Response to WSCC - Summer Lane, Pagham

1. This note has been prepared by Vectos in response to WSCC's comments on the Transport Statement (TS) in support of the erection of 90 dwellings with associated access and open space at Summer Lane, Pagham (Planning ref: P/58/15/OUT).
2. This note presents WSCC's comments in their entirety before providing a response.

DRAWING NUMBER: **120843/A/05** REVISION: **B**

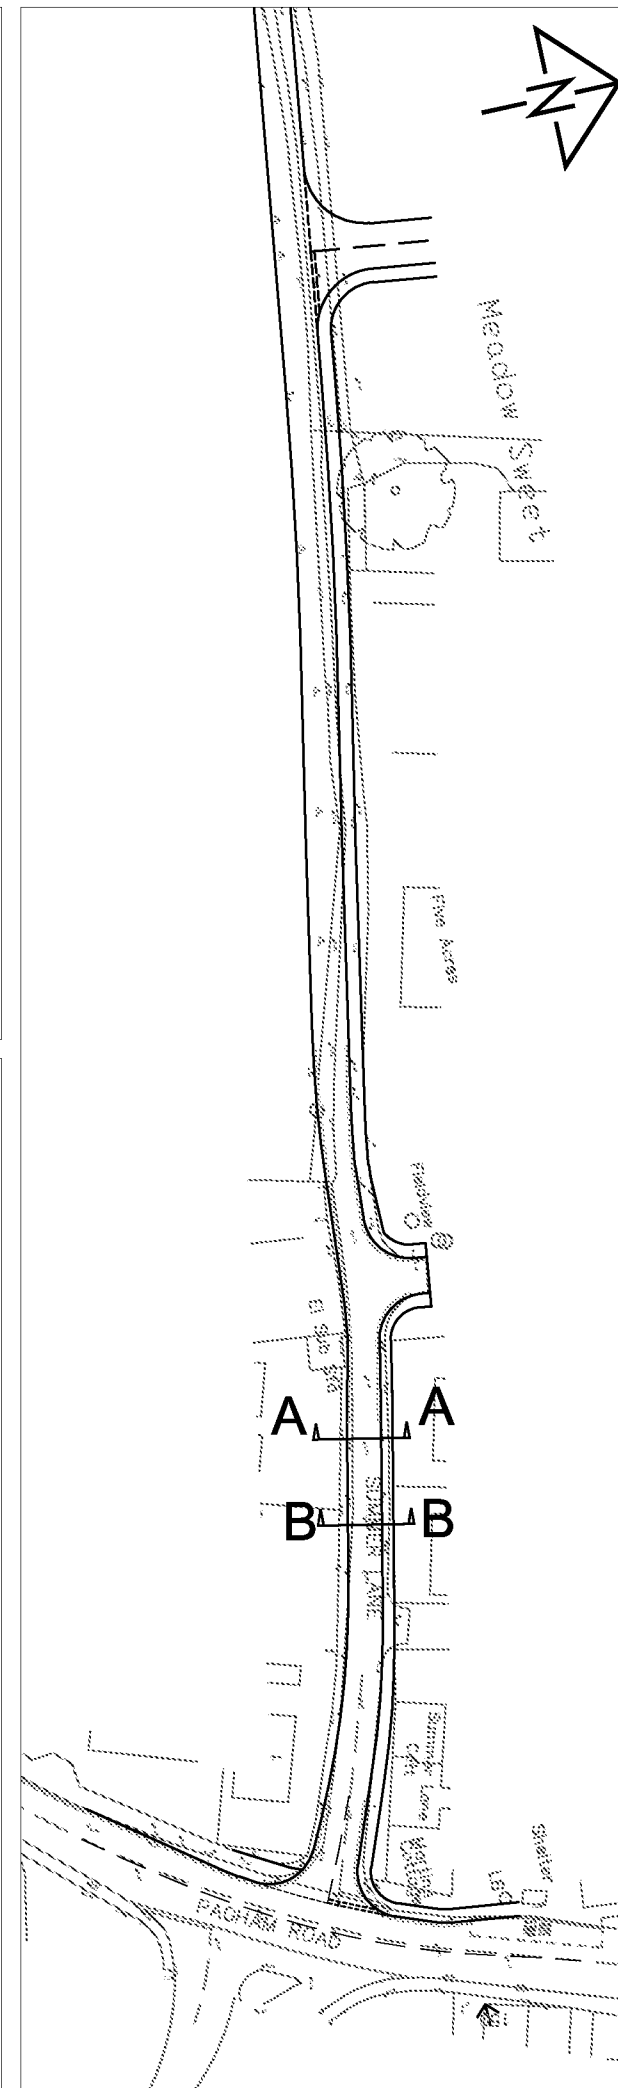
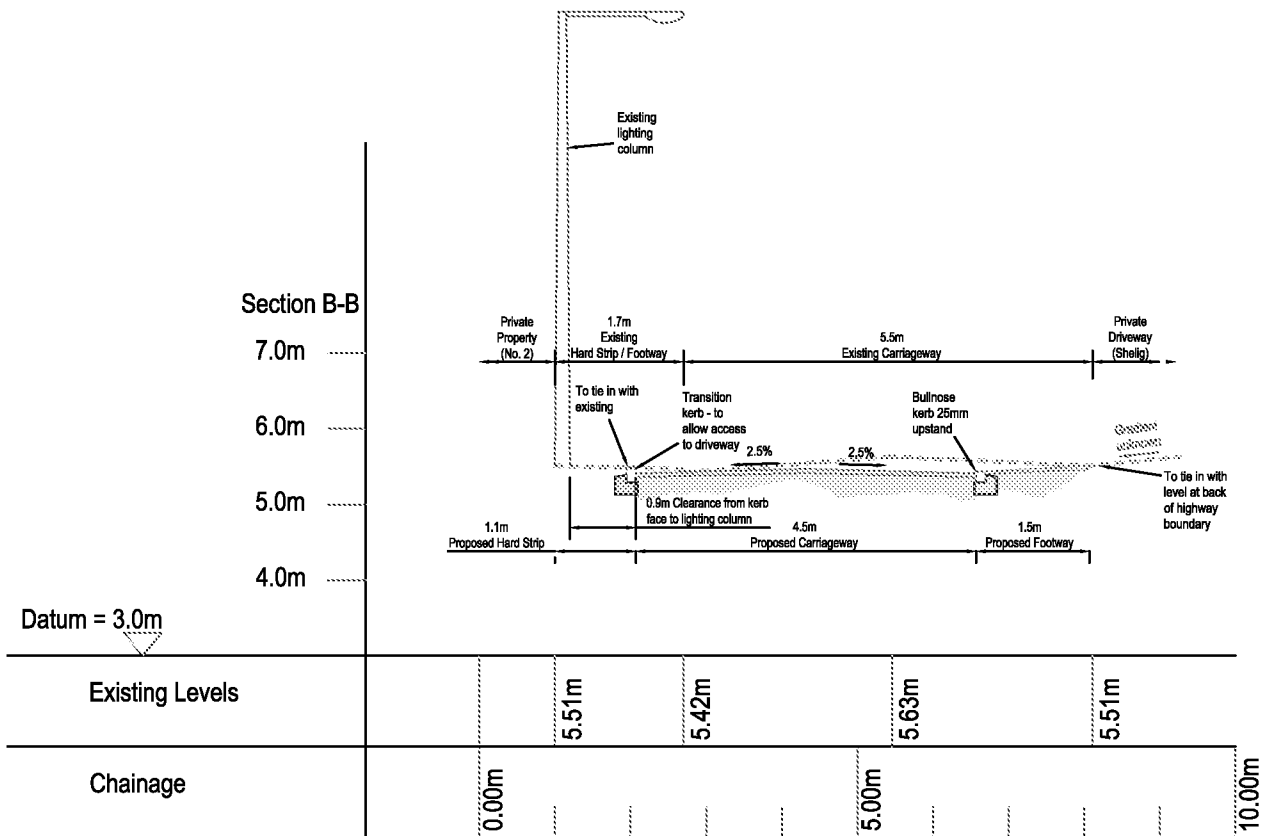
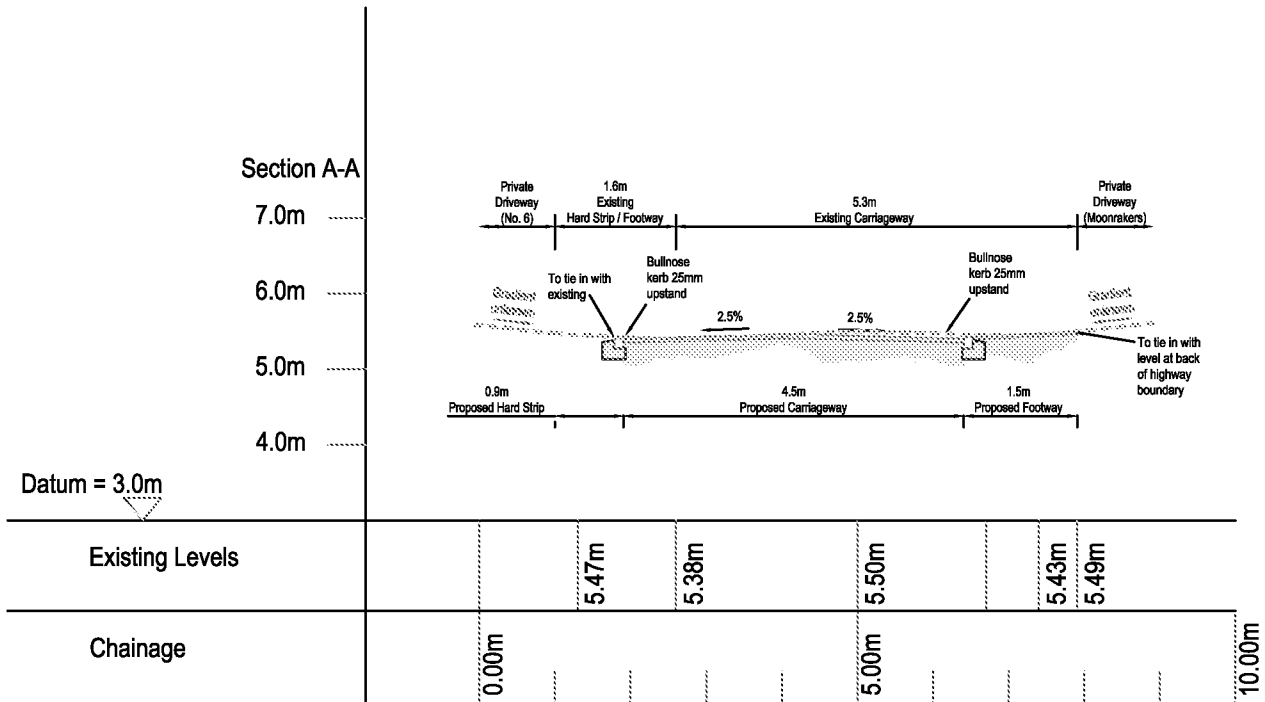
“There is also a potential issue relating to the build-ability of the footway arrangement as shown. There is quite a notable gradient on the driveways of the two properties, Moonrakers and Shelig. The gradient on both falls towards Summer Lane with the cross fall of Summer Lane appearing to fall towards these properties. The construction of a footway on the north side of Summer Lane would involve the building up of the carriageway to create a segregated arrangement. Due to the gradients on the driveways it’s unclear how the driveways would then tie into the footway without resulting in a significant step from the private driveways onto the footway. Alternately, works would be required to the driveways of both properties that lie outside of the control of the applicant and the LHA. It’s suggested that a cross section is provided showing the ability to provide the footway in light of the existing driveway gradients.”

11. As suggested, a cross section showing how the Moonrakers and Shelig driveways tie in is shown in drawing 120843/A/A05 Rev B. The plan has been informed by OS base mapping and chain lien/centre of road/back of highway boundary spot levels where available. This shows that the proposed works will tie in with existing levels to the rear of the highway boundary.

- Ex:16.71m Existing Visibility
- Pc:16.71m Proposed Visibility

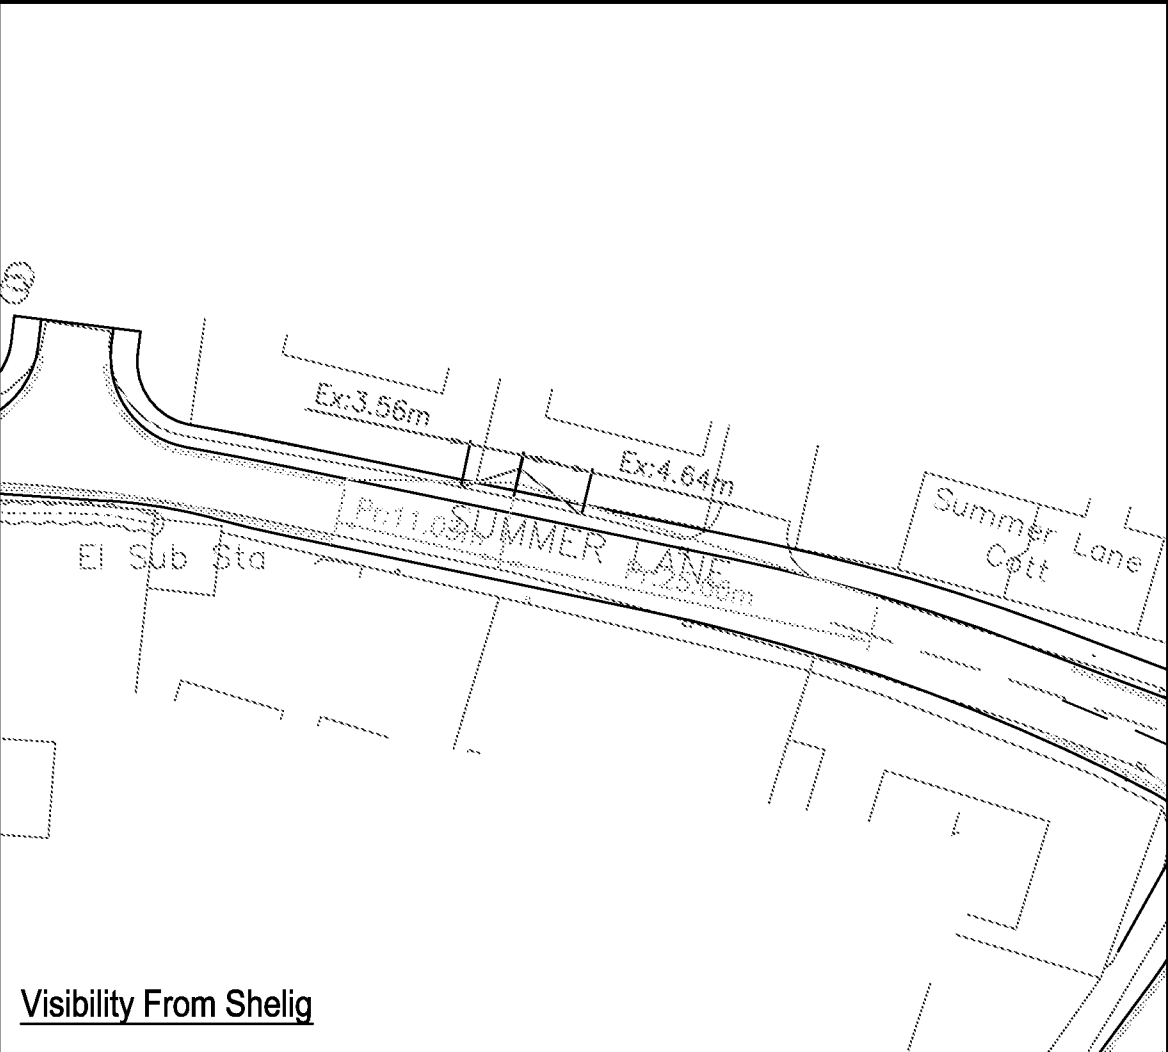
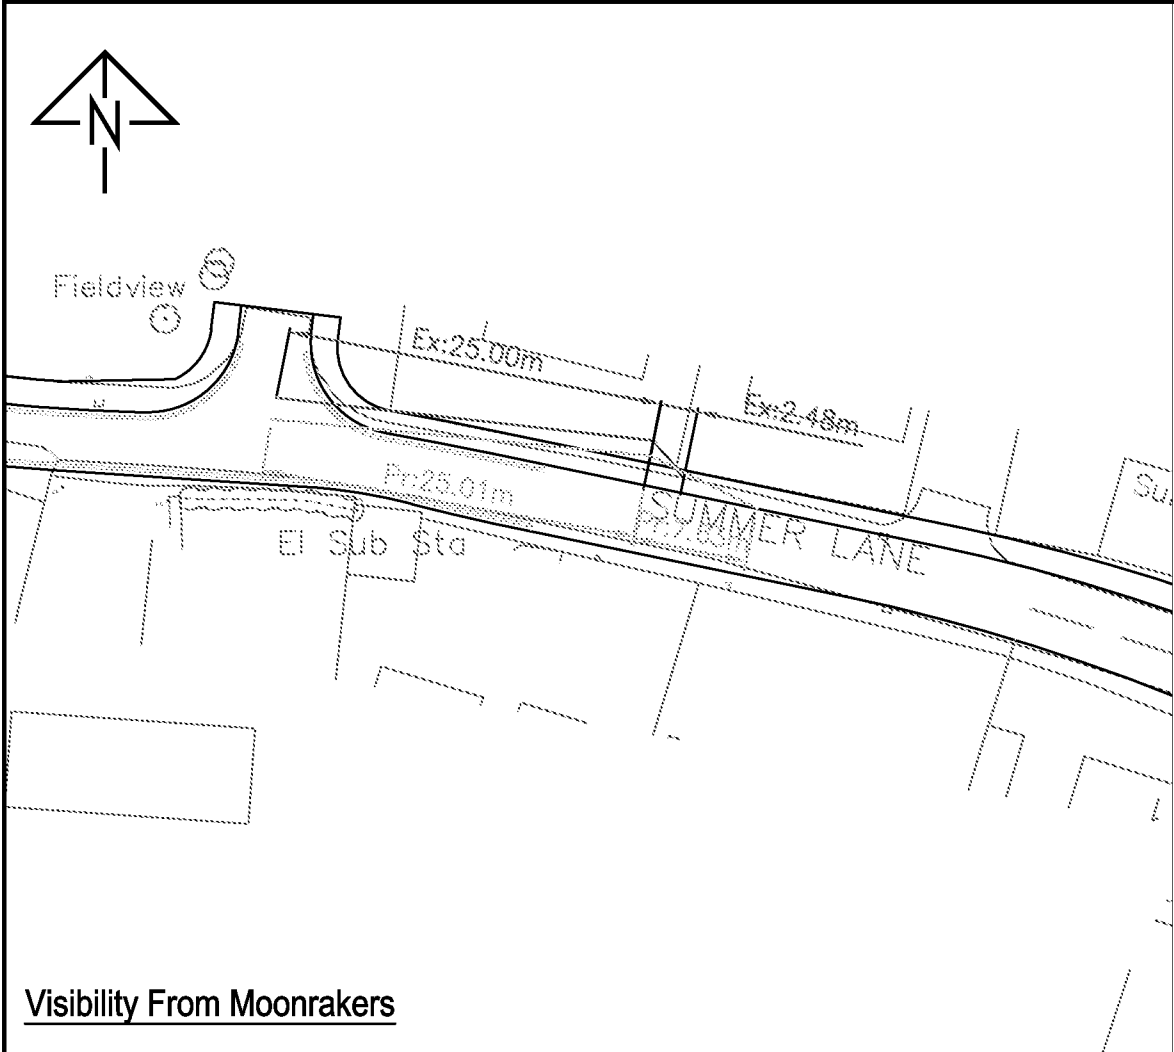
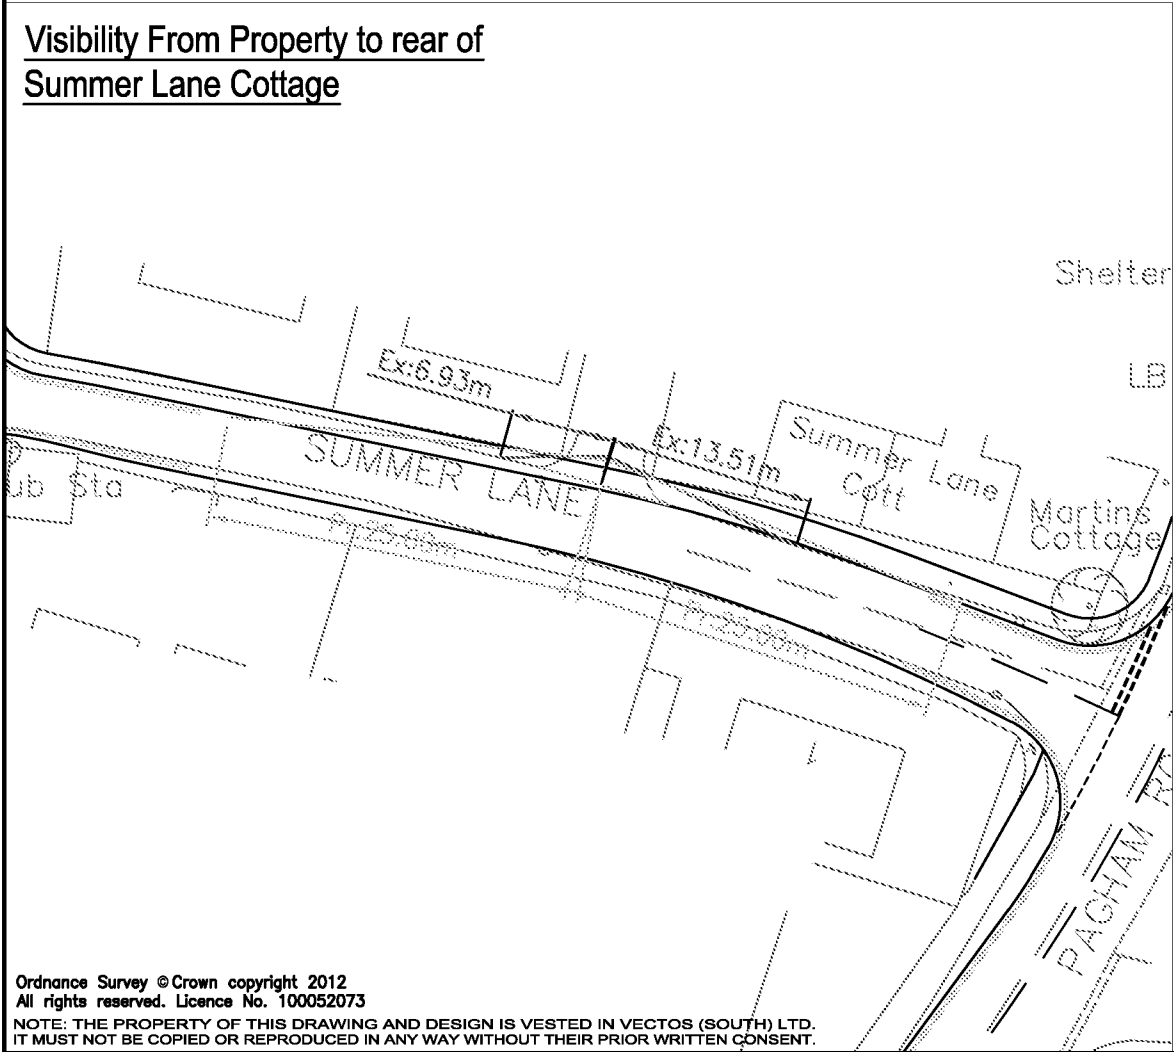
The arrangement shown would also involve relocating the existing narrow footway from the southern side of Summer Lane to the north. In principle, there would be benefit to this given the widening of the footway that would result. Removing the footway from the southern side of the carriageway may have consequences for visibility from the accesses for those existing dwellings. It would appear that visibility may be substandard based on the existing arrangements, the proposed works would potentially worsen matters. Again, this matter should be appropriately considered with it determined how much of an impact would result from relocating the footway.”

5. A comparison of visibility splays has been carried out to assess the impact of relocating the footway. For the effected dwellings, existing visibility splays and proposed visibility splays are shown in drawing 120843/SK/13 Rev A. As mentioned above the removal of the southern footpath does reduce visibility for residents. The worst reduction in visibility is 7.98m from 12.33m to 4.35m. Visibility splays have been produced to show a worst case scenario by adhering to property boundaries. However in reality visibility will be unobstructed due to low level vegetation on property boundaries and will therefore effective visibility will be similar to existing levels.

6. Following initial comments from WSCC, a short stretch of Summer Lane the carriageway has been narrowed to 4.5m and the footway has been narrowed to 1.5m. This improves visibility for properties along Summer Lane once the footway has been moved to the northern side of the road. It is worth noting that while visibility for properties along the southern side of Summer Lane may be reduced, visibility for properties along the north side of Summer Lane will be increased. Drawing 120843/SK/14 Rev A shows the increase in visibility for the properties along the northern side of the road. The biggest increase in visibility is from Shelig, where visibility has increased from 4.64m to beyond 25m.
